KITTITAS COUNTY DEPARTMENT OF PUBLIC WORKS

MEMORANDUM

TO: Jeff Watson, Community Development Services
FROM: Christina Wollman, Planner II *CW*
DATE: August 1, 2011
SUBJECT: Loosmore BL-11-00014

PROPOSED

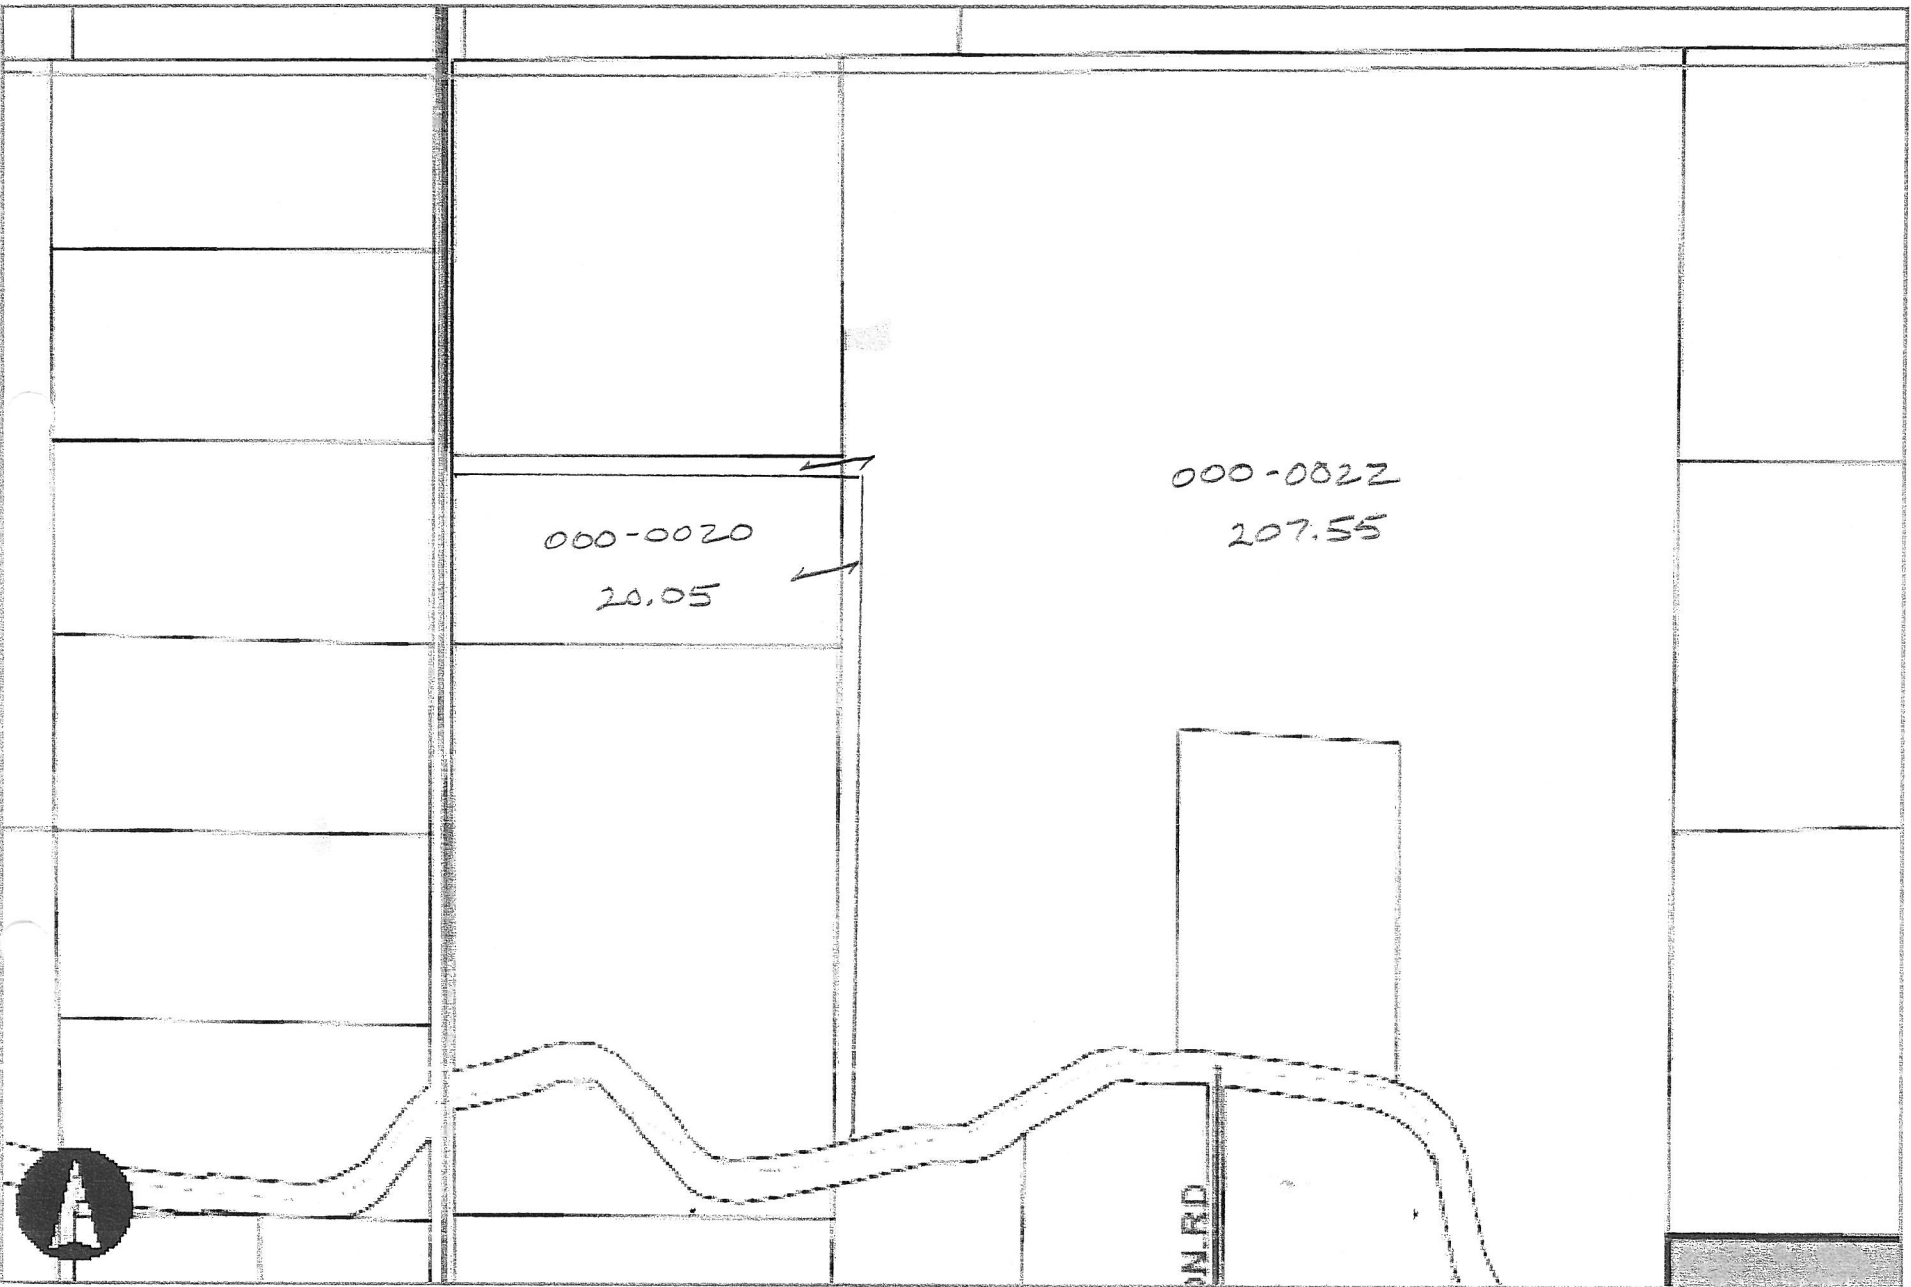
1. The proposed access with appropriate easement(s) shall be shown and shall conform to applicable Kittitas County Road Standards.
2. A revised legal description that describes the final configuration of the subject property shall be required.
